From: Sue Howell <Sue.Howell@arun.gov.uk>
Sent: 24 June 2020 09:40
To: Planning.Responses <Planning.Responses@arun.gov.uk>
Cc: Anita Gardner <Anita.Gardner@arun.gov.uk>
Subject: RE: Planning Consultation on CM/14/20/DOC

APPLICATION NO: CM/14/20/DOC

Site Address: Kents Yard Brookpit Lane Climping BN17 5QT

Description of Works: Approval of details reserved by condition imposed under ref CM/19/17/PL relating to Condition Nos 3 - Construction Method Statement & Details, 6 - contamination, 9 - bats, 10 - owl box locations, 11 - nesting cups and 13 - hard & soft landscaping

LANDSCAPING SCHEME 1:200@A2

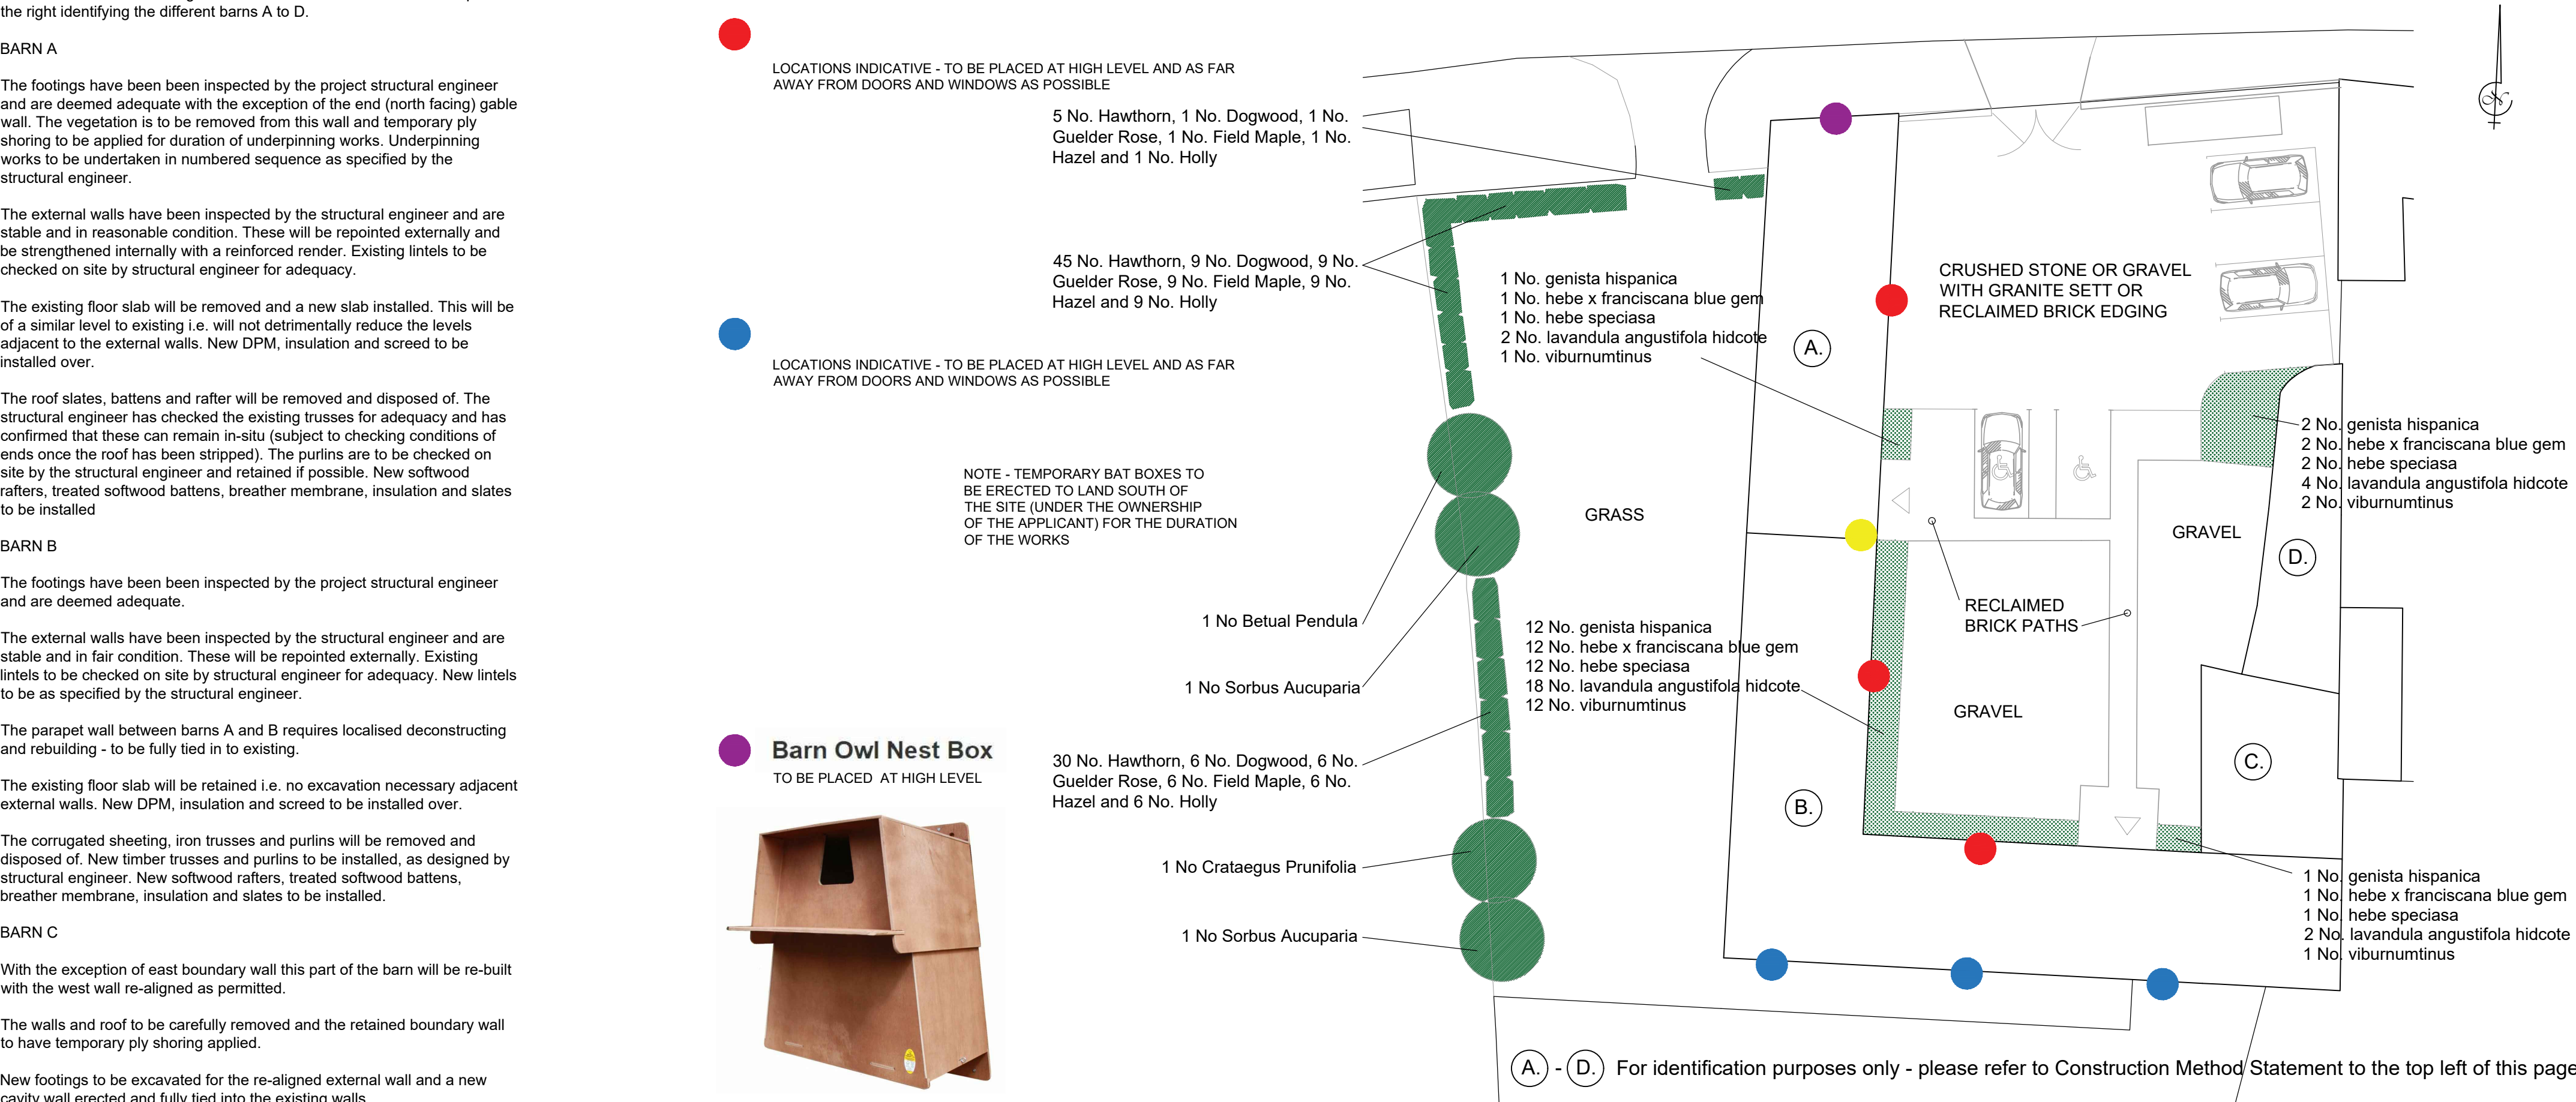
This application requires further information to be shown ie

Actual quantities to be provided in location for the shrubs and hedging proposed and which trees going where for the trees indicated, shown also on the plan.

Please can this information be requested to be submitted in plan form. Happy for this to be hand annotated onto the plan 1169/Figure 1 Rev 2 as only a minor amend.
